DECISION DELEGATED TO HEAD OF PLANNING

Application No: H11-0288-24 **Applicant:** Mrs K Bearman, Mr J Goodman & Miss K Lloyd

Proposal: Erection of a single new dwelling

Location: Adjacent To 9 Delph Road Long Sutton Spalding

INDICATIVE BLOCK PLAN AS
PROPOSED
SCALE 1/500 @ A3

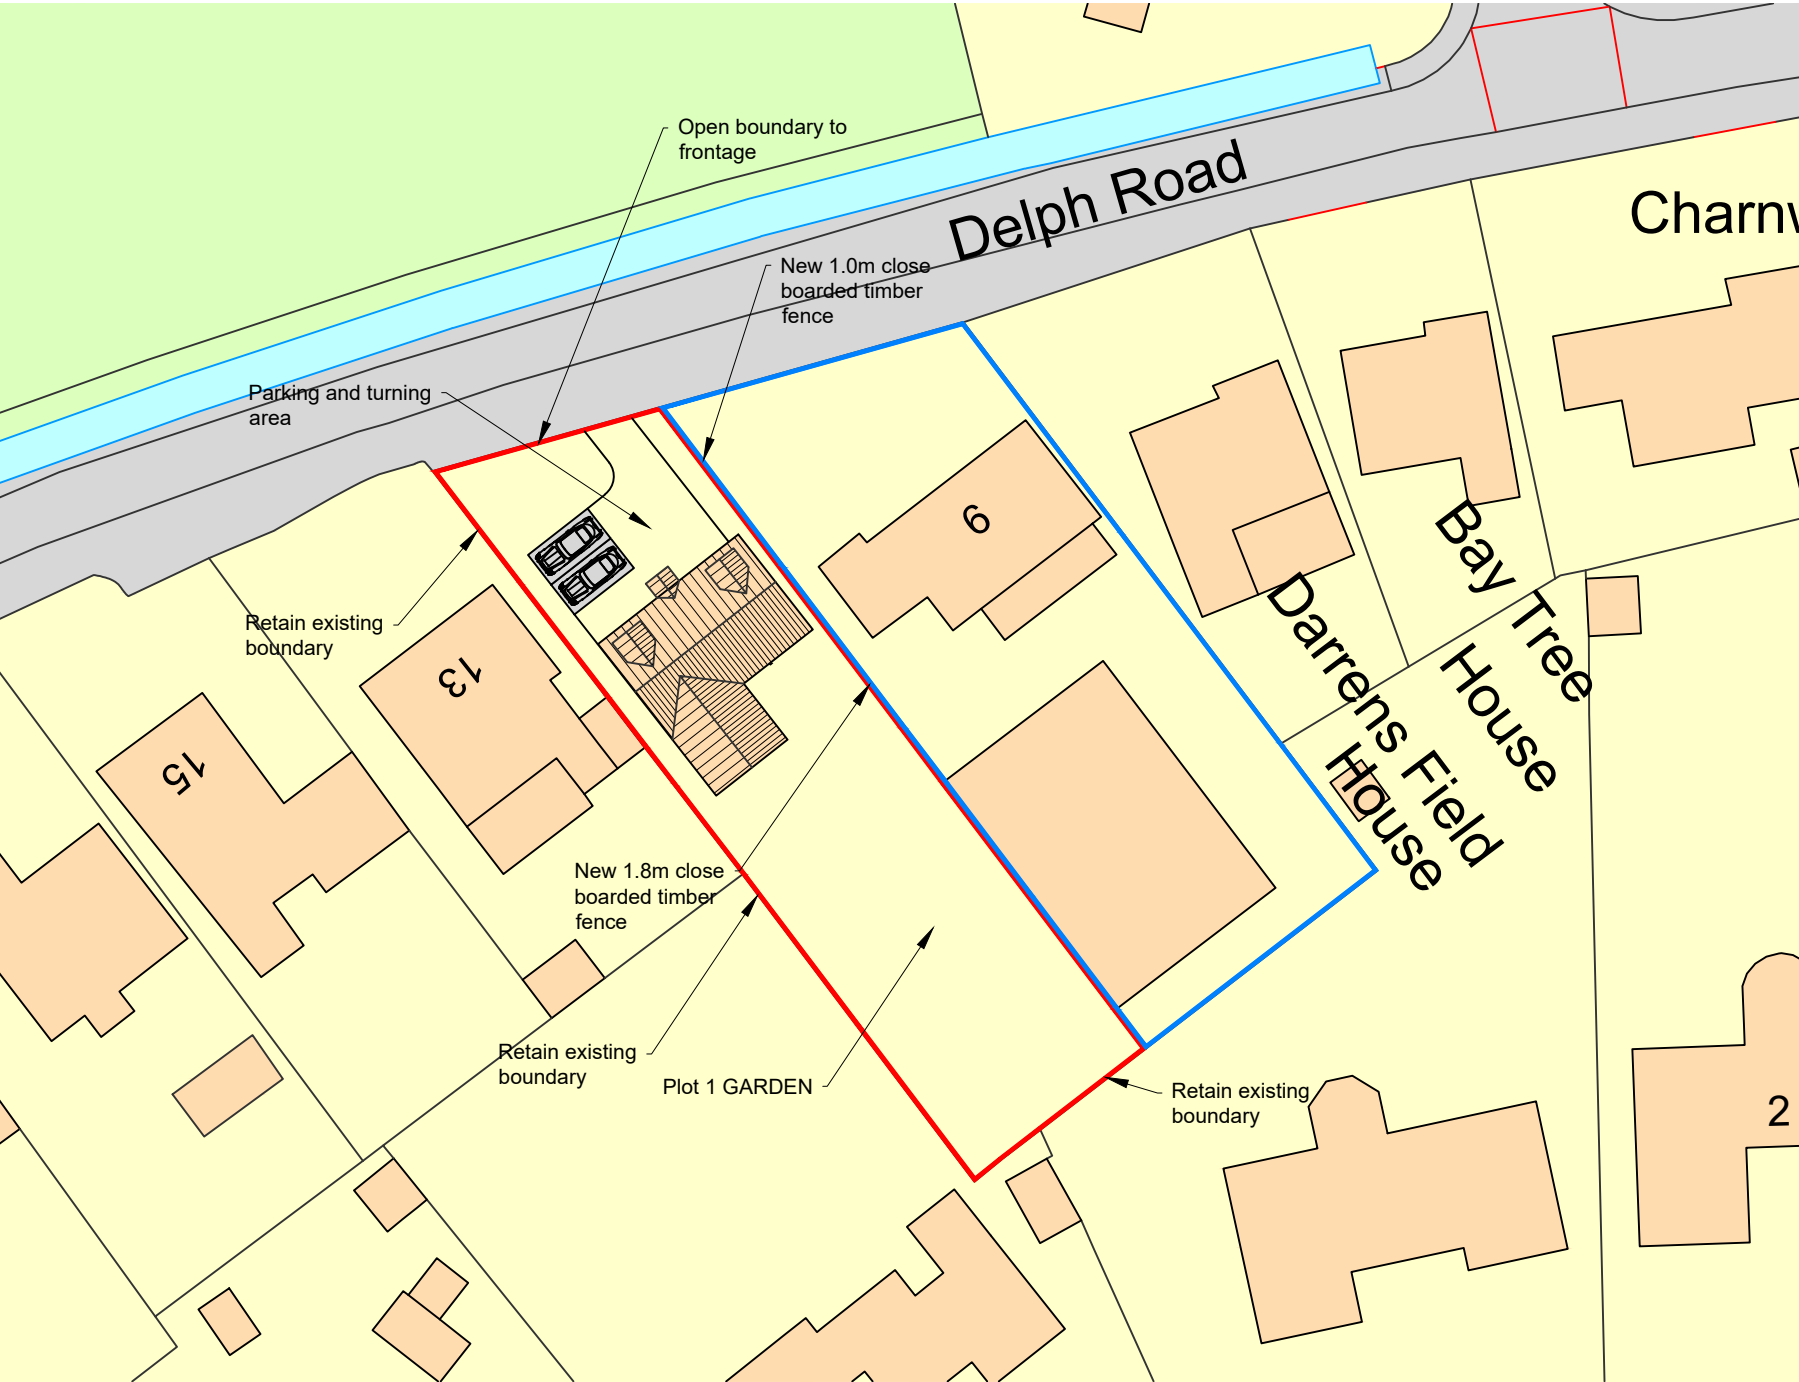
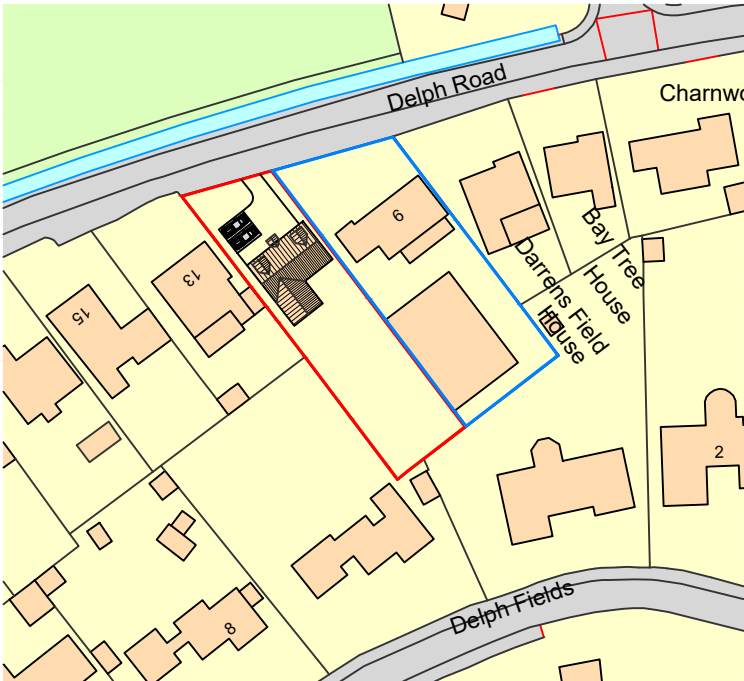
The proposal is in outline form; however, an indicative site layout plan has been provided alongside a covering letter. Within the covering letter it states that a chalet style bungalow would be best suited within this site to retain the character, as the surrounding area comprises a bungalow and a chalet bungalow within the immediate vicinity. The indicative plan also shows that the site could accommodate such a property, with the dwelling itself being shown to be brought forward in comparison to that of No.9 Delph Road, allowing a continuation of the slightly staggered linear pattern along Delph road to remain. The size appears to be proportionate in relation to the plot and other dwellings but details on the design are of course reserved.

The indicative layout illustrates that a dwelling could be accommodated as to face directly onto the public highway with the access driveway connecting to this. It demonstrates sufficient space and sits well within its plot to ensure it does appear cramped whilst also leaving adequate room for the existing 9 Delph Road. Both properties would have ample amenity space. One dwelling would be an acceptable quantum of development and is of an appropriate density insofar as there would not be overdevelopment.

The application has been submitted in outline form with all matters reserved; as such, the LPA are unable to fully assess the potential overlooking impact of the future dwelling. However, the indicative layout and illustrative scale of the development, comprising a chalet bungalow, demonstrates that the site can accommodate such a development without causing an unacceptable adverse impact in this respect and without resulting in unacceptable views, subject to the

Furthermore, the same can be said for the overshadowing aspect of this plot. The finished floor levels will be raised 400mm from the existing ground level of the site, this coupled with the likely chalet style design ensures that the levels would not be raised to a harmful level. Finally, this also ensures it will not appear overbearing on the street scene as well other neighbouring properties.

Whilst the indicative plan shows that there are two spaces provided to the front of the property, as this application has been submitted in outline form, the details of access and parking have not been provided.
